Suffolk County Council (20041323)

Post-Hearing Submission for the Third Issue Specific Hearing (ISH3) into Transport and Rights of Way

Bramford to Twinstead (EN020002)

Deadline 4

NATIONAL GRID (BRAMFORD TO TWINSTEAD REINFORCEMENT) ORDER
 PINS APPLICATION NUMBER: EN020002
 TREES AND HEDGEROWS TO BE REMOVED OR MANAGED PLANS
 REGULATION 5(2)(e)
 SHEET 07 OF 30
 IN THE DISTRICT OF BABERGH DISTRICT COUNCIL

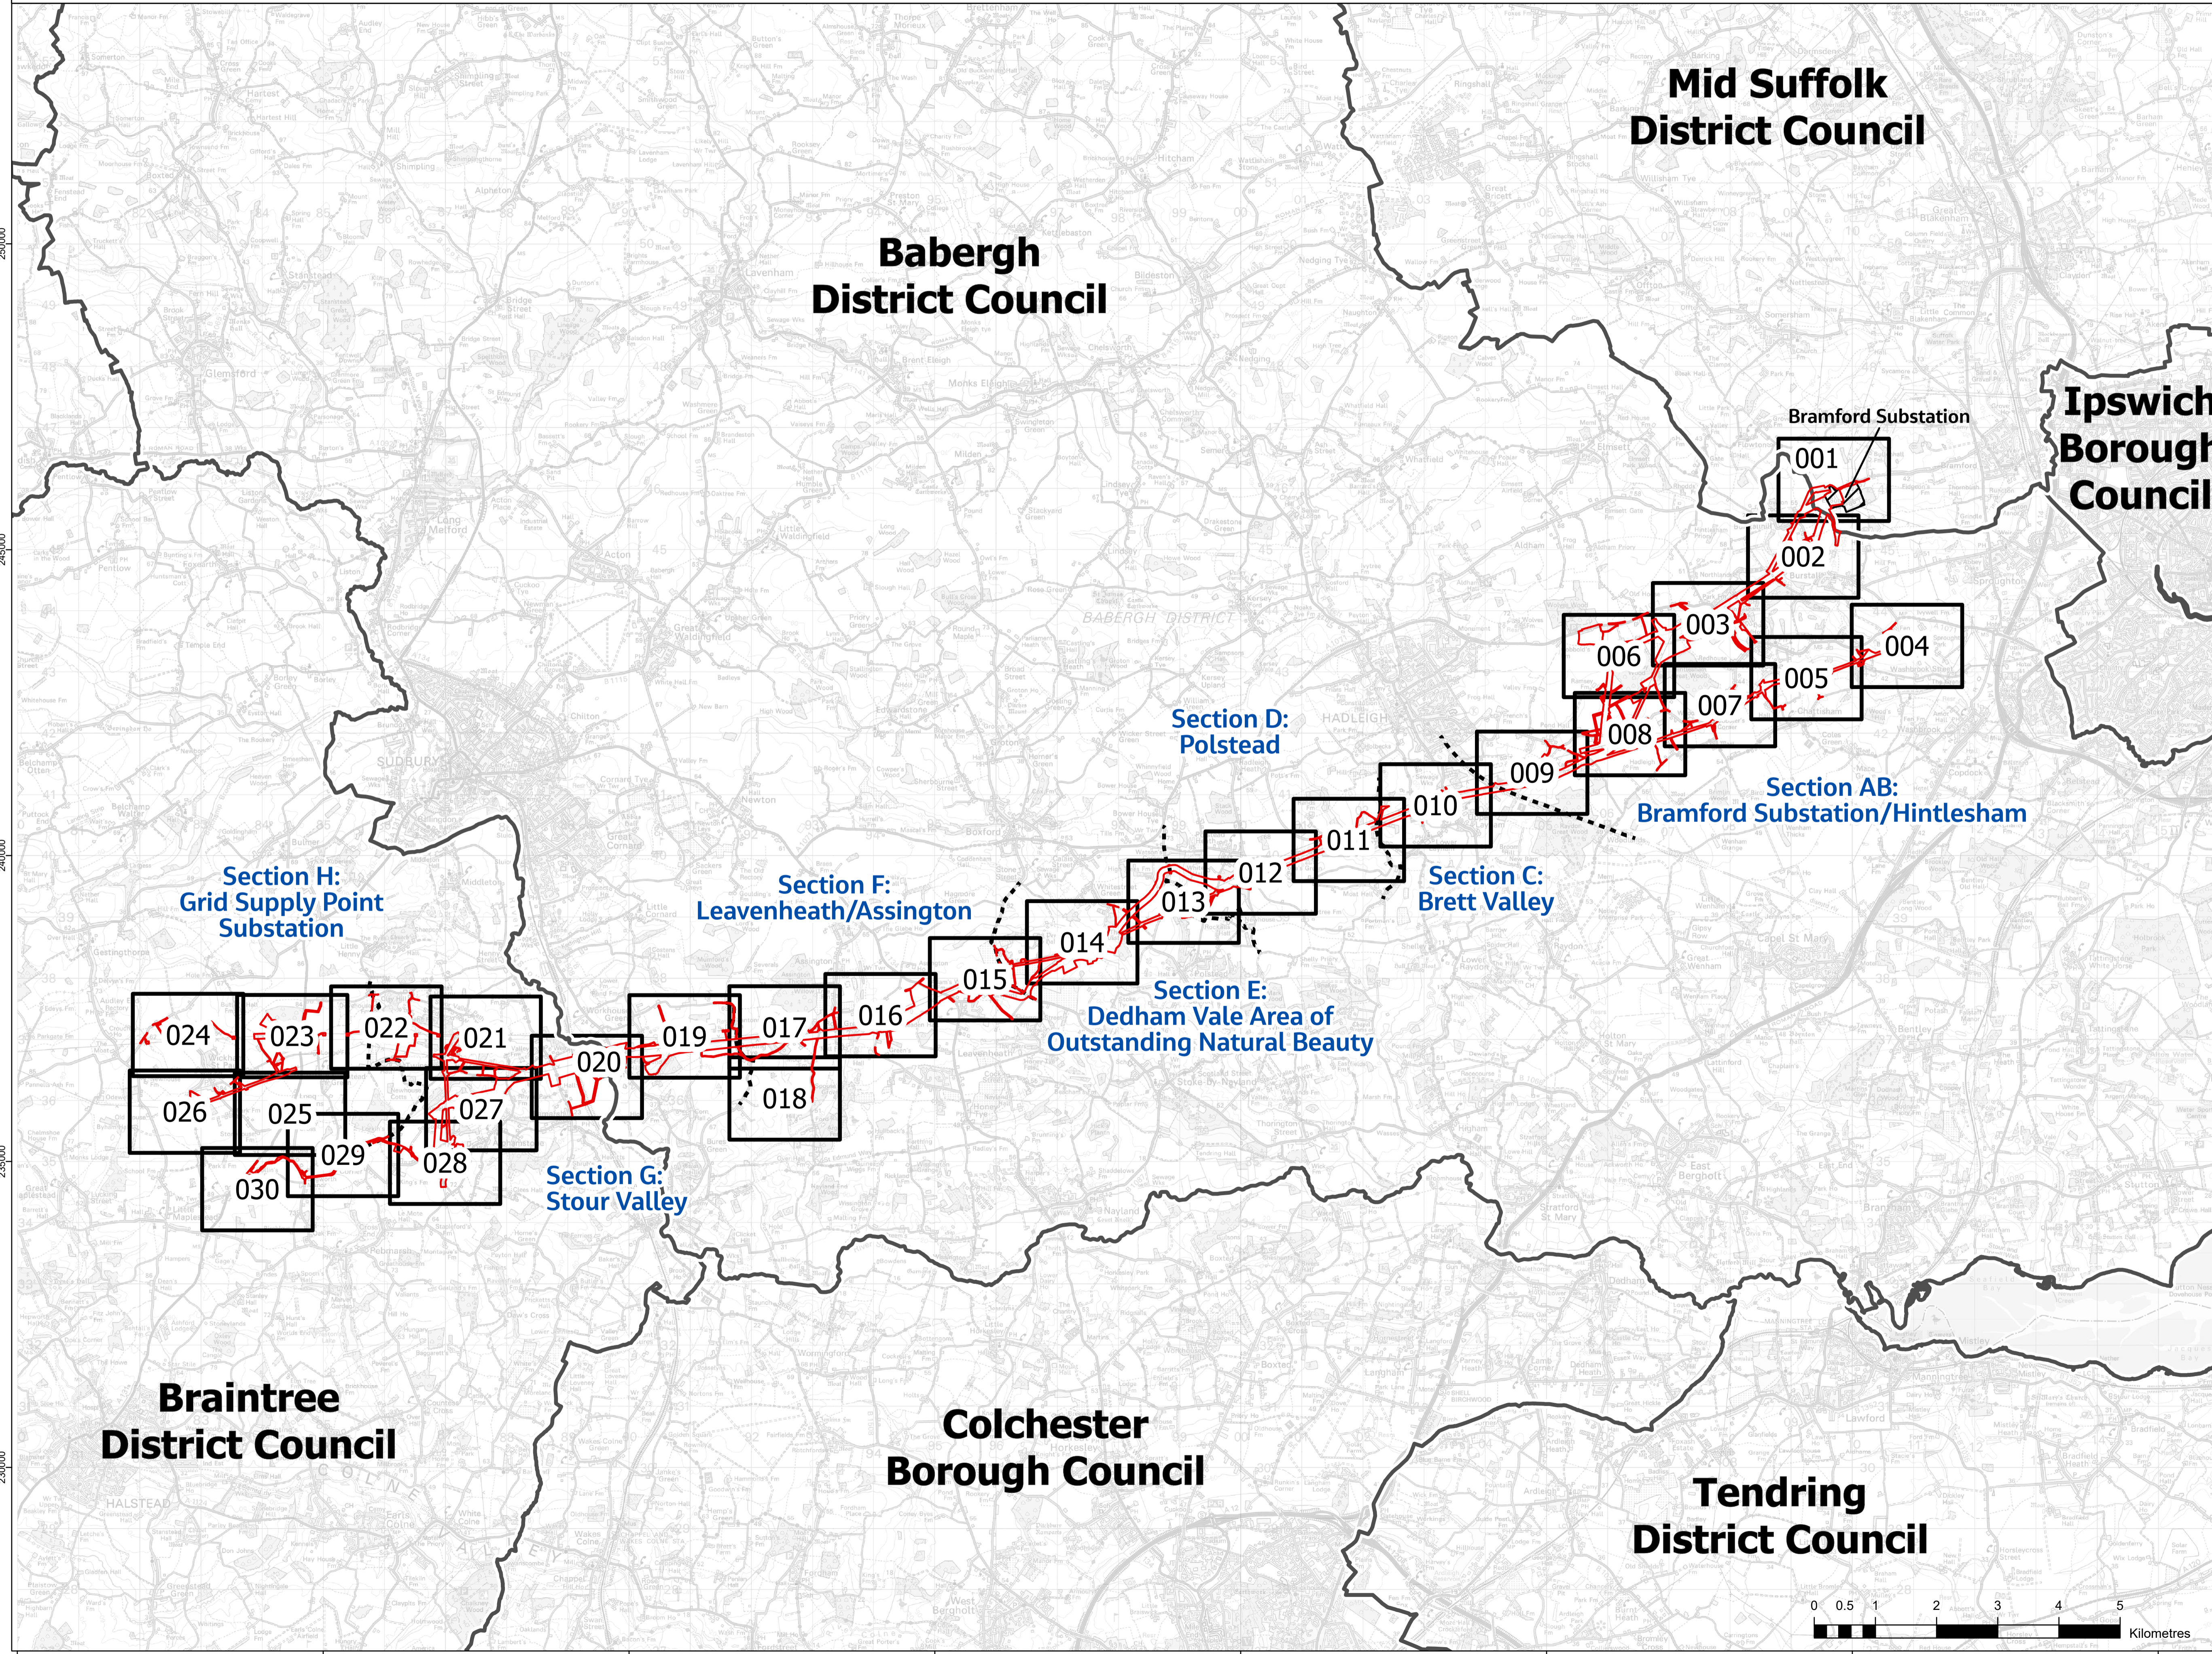
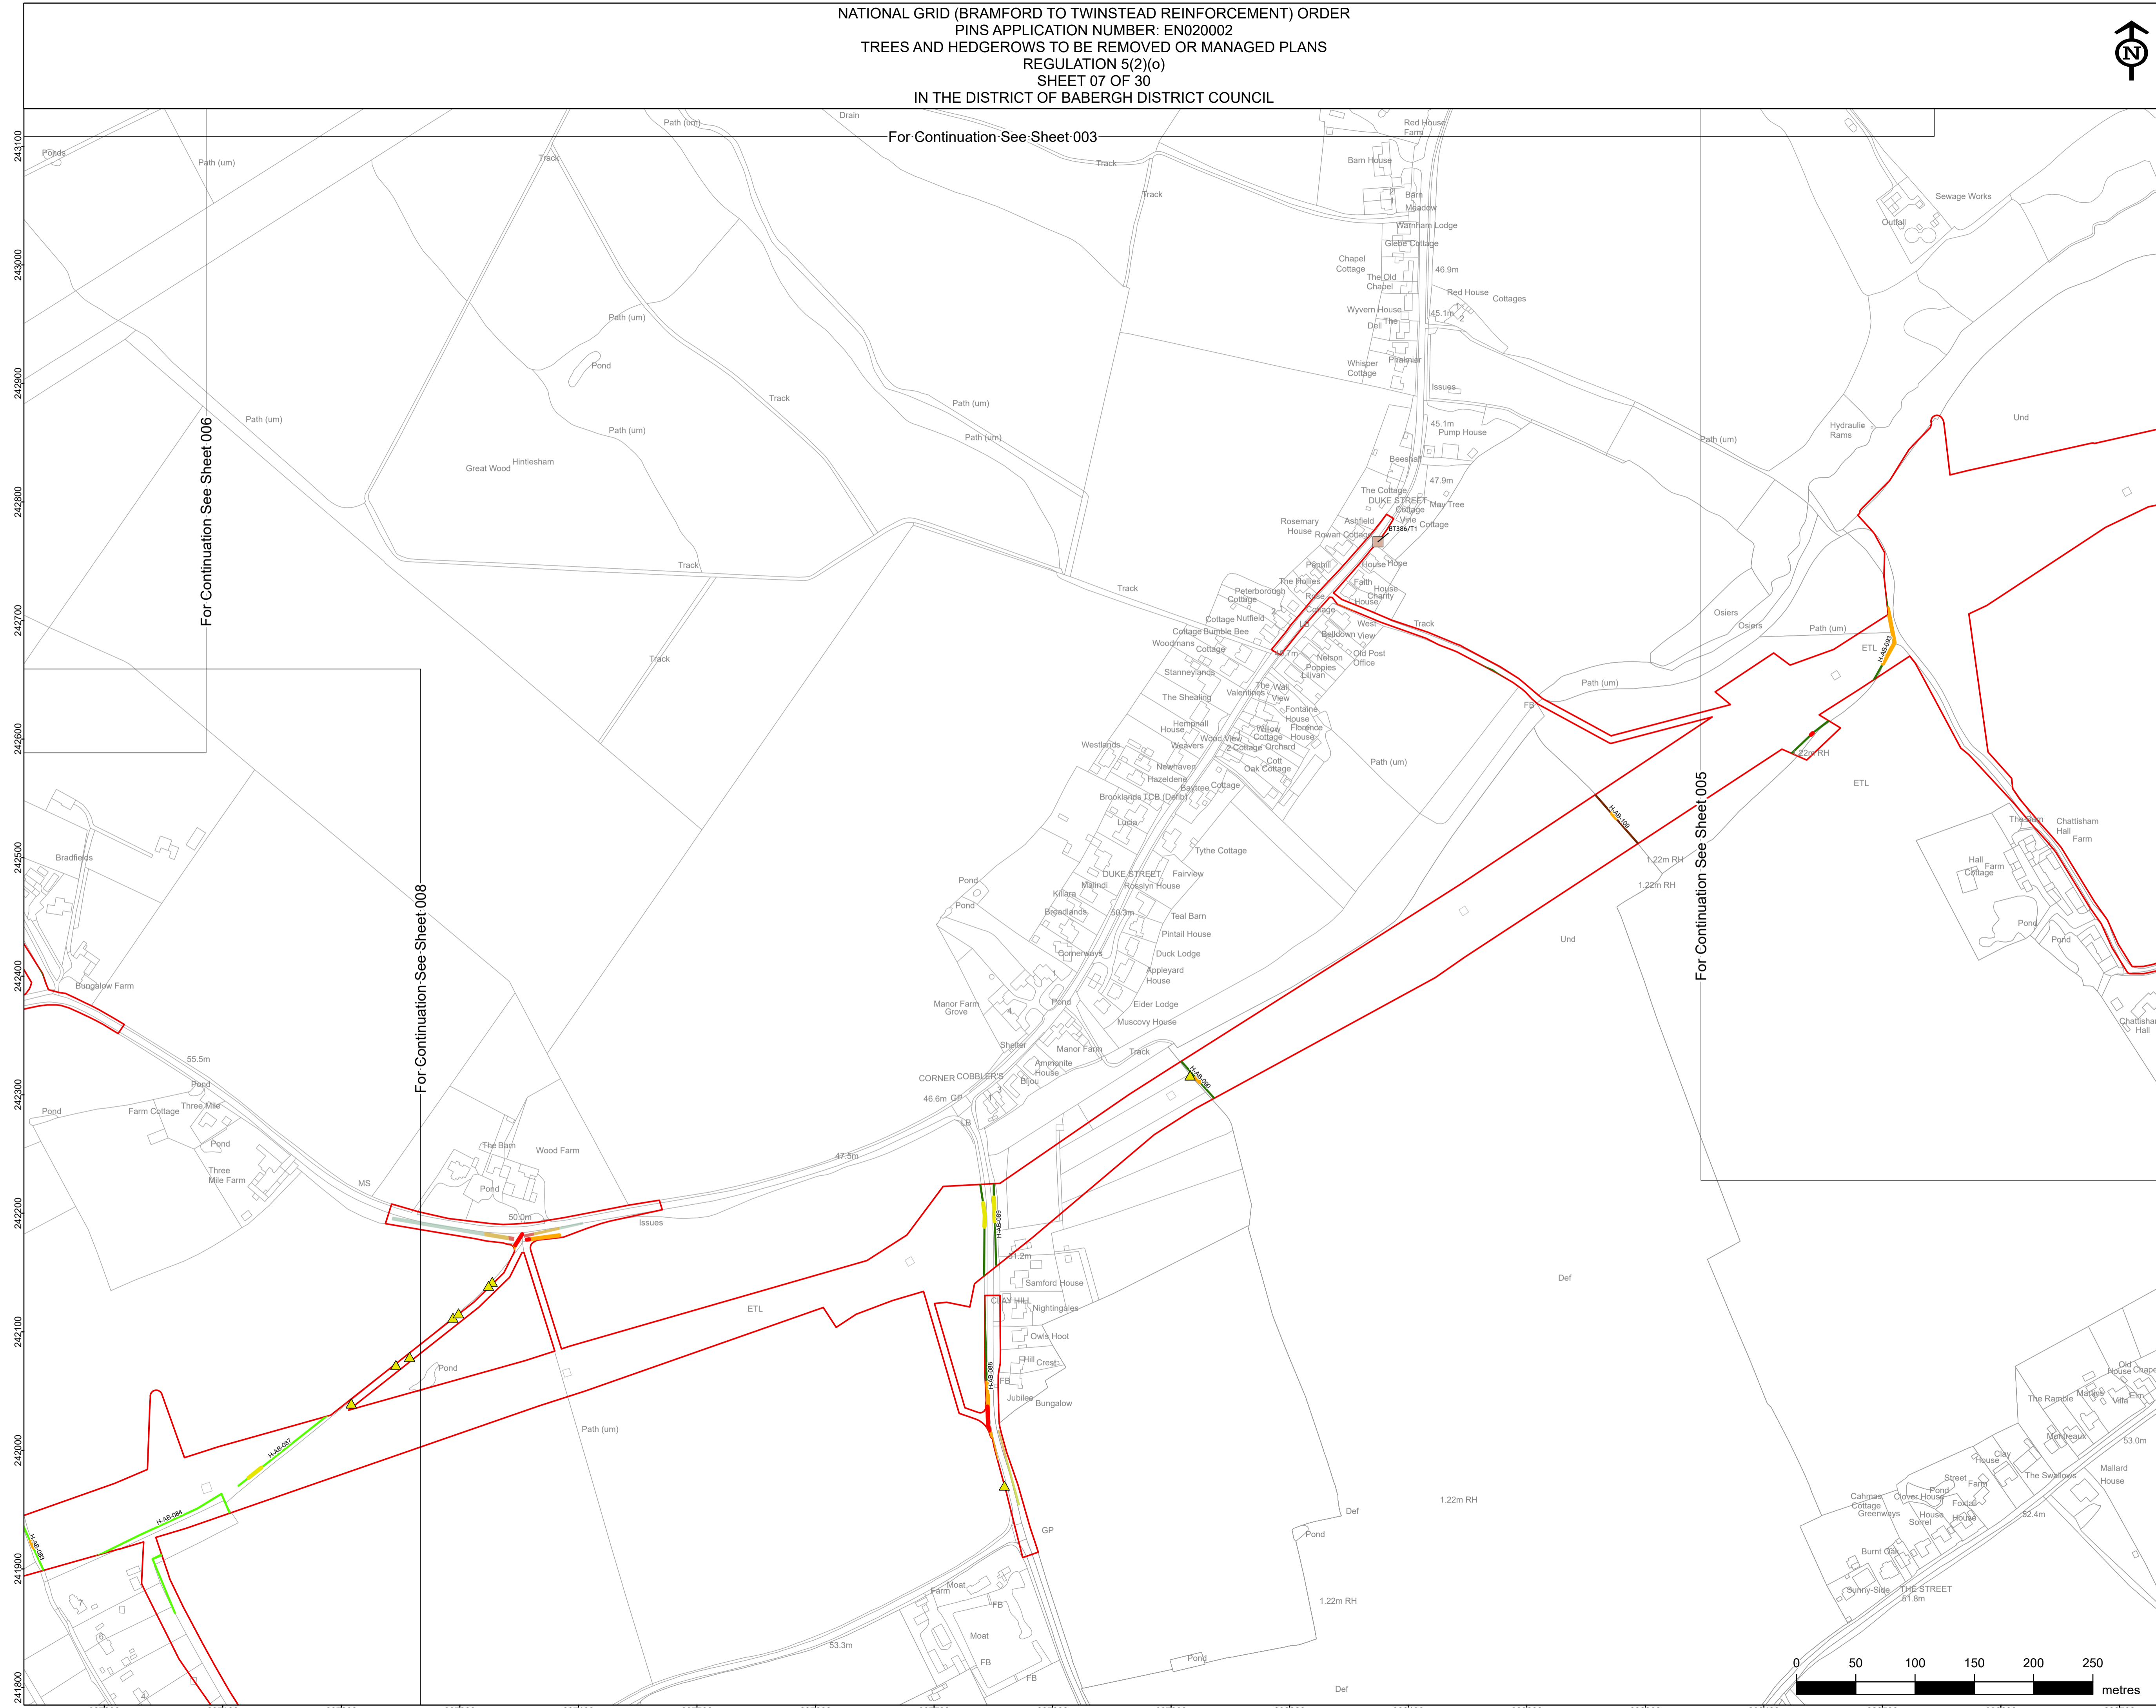
The plans provided are of such large scale to make it difficult to measure the areas proposed for visibility splays.

An example from Church Hill, Burstall in our option shows the issues. The road is currently derestricted but will be subject to a temporary 30mph limit during construction. Even allowing for such a temporary speed limit having good compliance, this will still require a 2.4m x 90m visibility splay as required as by the Suffolk Design Street Guide 2022 Appendix F (see Appendix 1). This would necessitate significant trimming if not removal of trees and hedges. SCC also notes that pollarding / raising the crown of trees whilst practical for individual trees would not resolve the visibility issues if there were a line of trees.

A second example is the permanent access D-DAP2 off Millwood Road, Polstead. The road is derestricted (60mph) and as the temporary speed limit will be remove post construction will require a 2.4m x 215m visibility splay to conform with design standards in the operational phase. The 'Trees and Hedgerows to be Removed or Managed Plans' sheet 12 only shows the hedges to be coppiced which unless repeatedly cut (to 600mm agl) would not provide acceptable visibility. It is noted that the visibility for D-DAP4 on inside of the bend will also be poor.
